NEWRIVER, FOUR ASHES PUBLIC HOUSE, FOUR ASHES

PINS REF: TR050005

CONNECT TECHNICAL NOTE 02 – OBJECTION ON BEHALF OF NEWRIVER TO PROPOSED RIGHT TURN BAN AT THE A449 STAFFORD ROAD / STATION ROAD JUNCTION

18TH JULY 2019

FIGURE No:  
 FIGURE L8

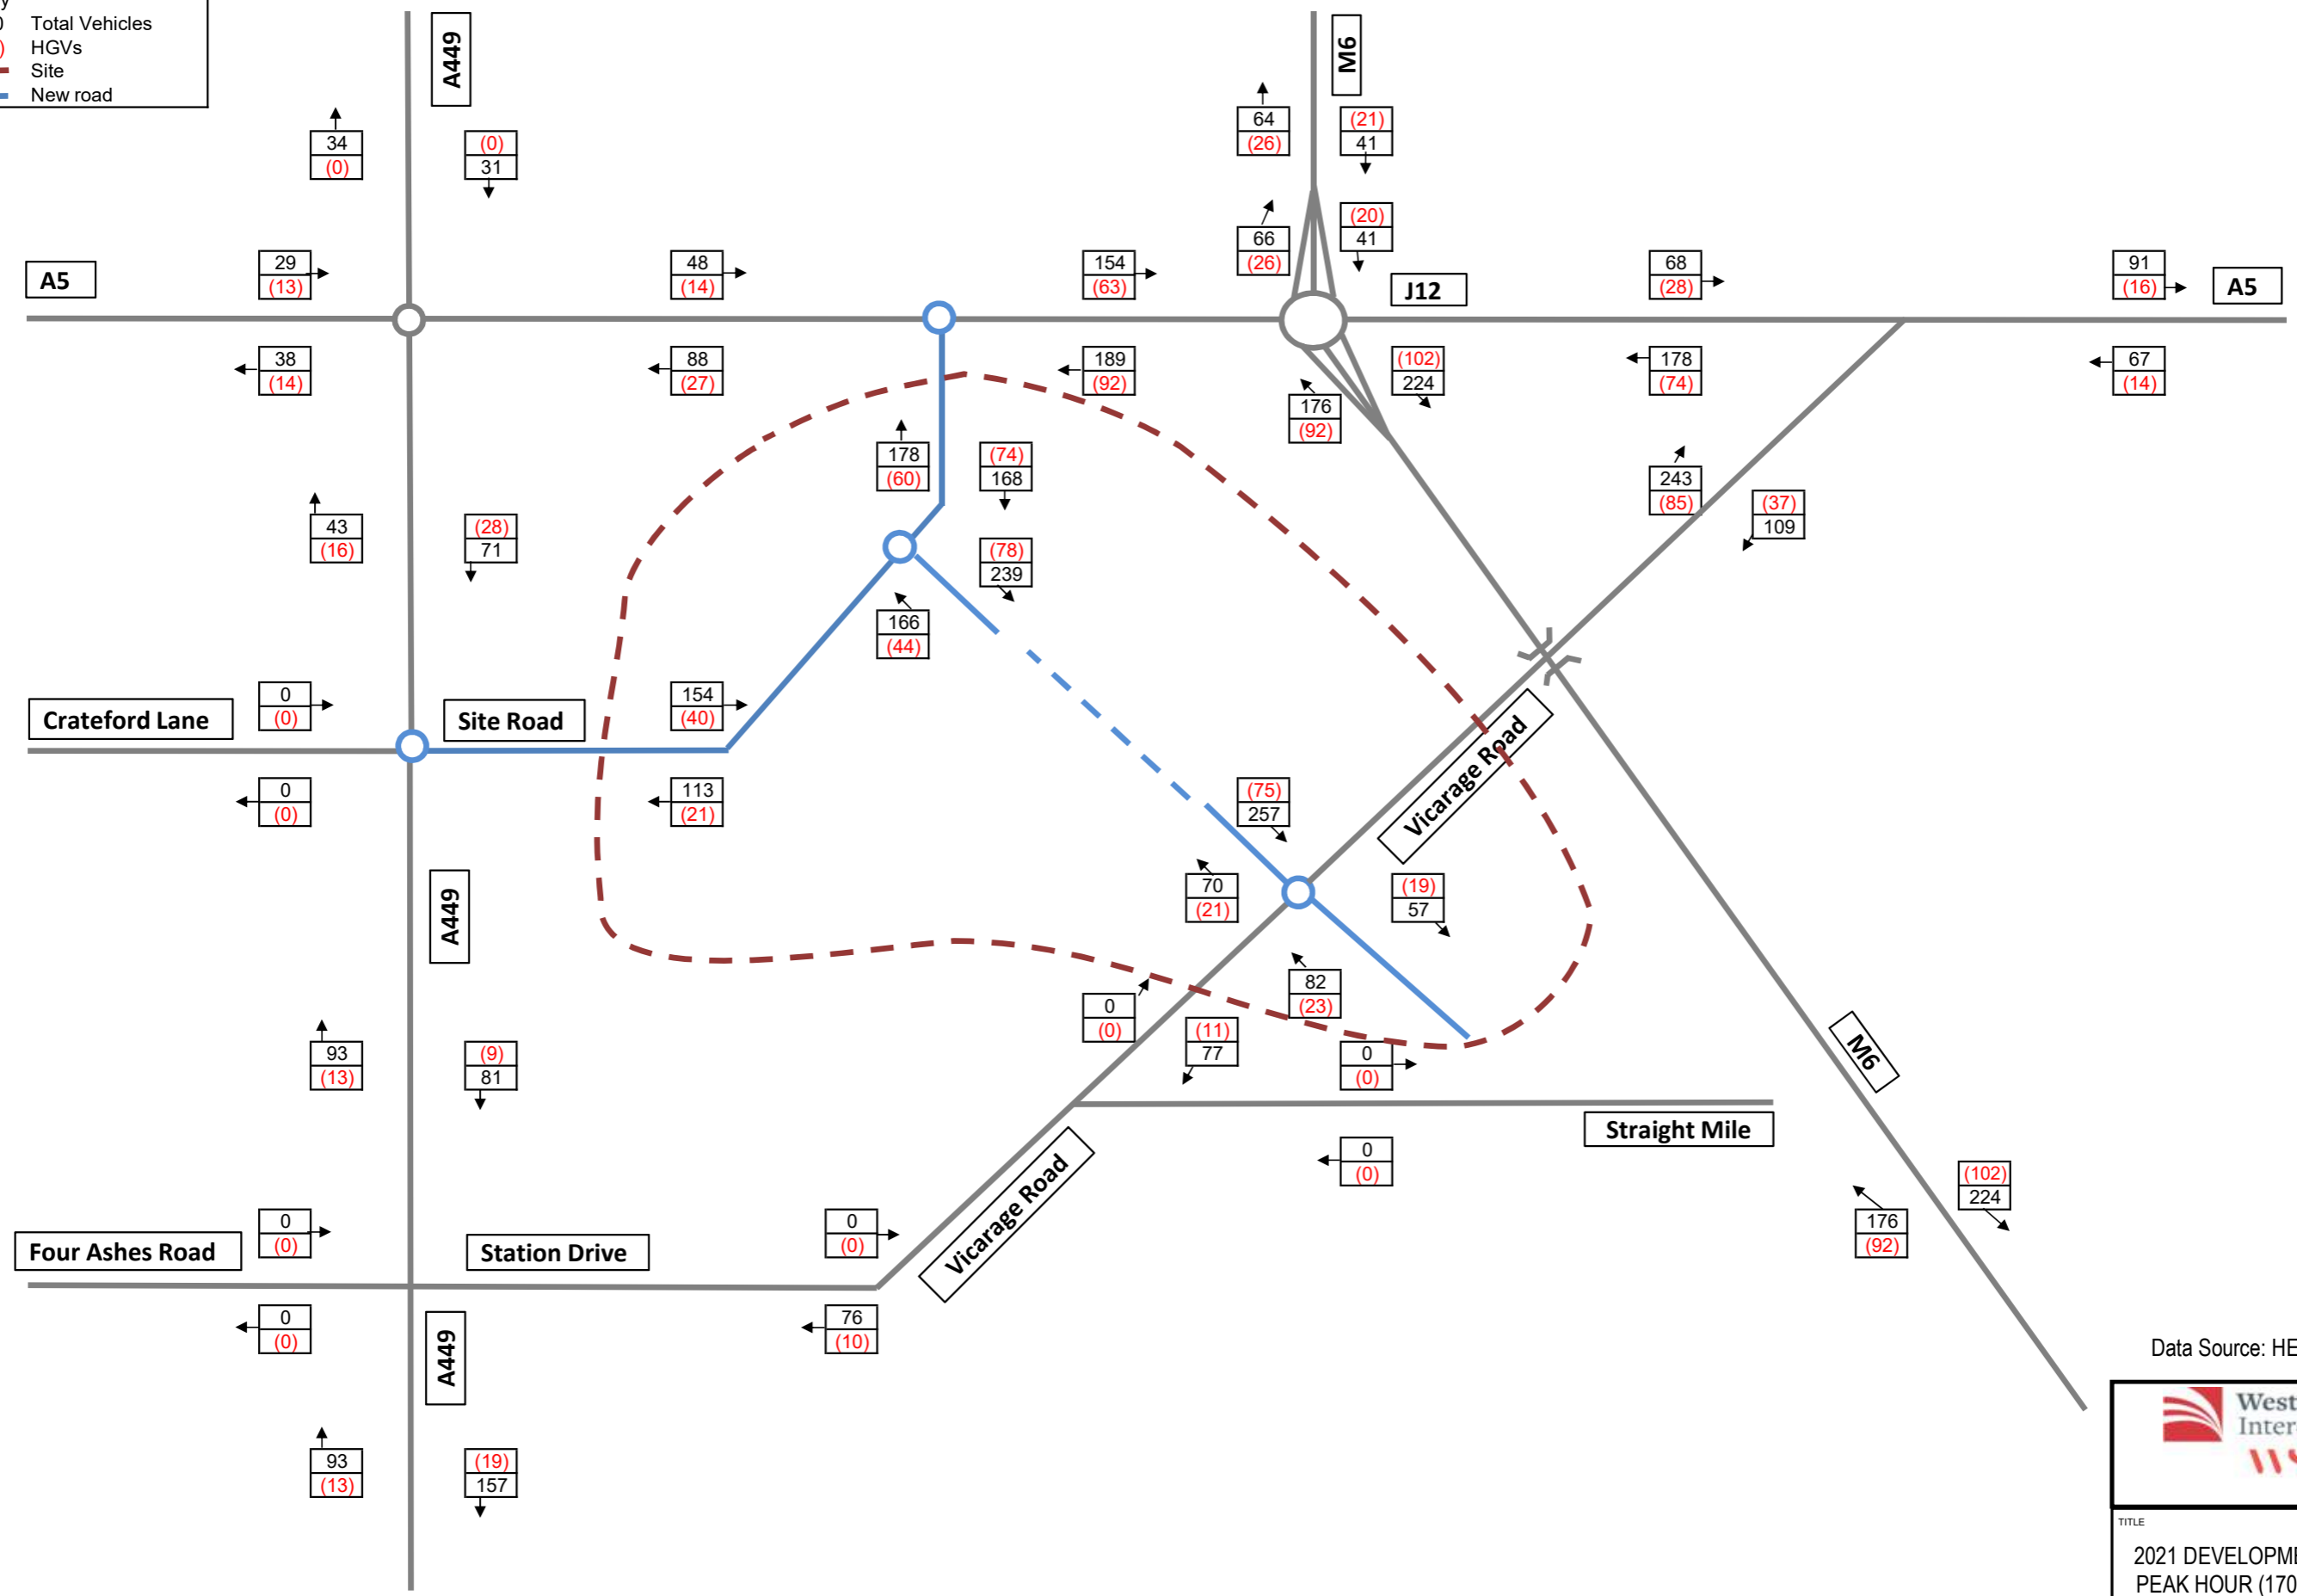
- 2.4 This technical note, Connect Technical Note 02, provides commentary on WSP TN42.
- 2.5 It should be noted that, at the hearing which Connect attended, Connect highlighted errors in the applicant's traffic flow diagrams regarding northbound and southbound predicted traffic flows along the A449 between Station Drive and the proposed link road.

- 2.6 Connect noted that the traffic leaving one junction was significantly different from the traffic arriving at the next junction, despite there being no other junctions in between. The 'baseline' flows had identical traffic leaving one junction and arriving at the next, and therefore the error must have arisen in the 'proposed development' flows.

- 2.7 Email correspondence between Connect and WSP has resulted in WSP suggesting that the missing traffic is related to U-turning movements at the A449 / Link Road roundabout, and that the error on the diagrams does not affect modelling output.
- 2.8 We note that no corrected traffic flow diagrams have been issued, and casts doubt over the reliability of the analysis, and it raises the question of what other movements have been excluded from the publically available diagrams and information, which also relates to the wider issue of transparency and scrutiny.
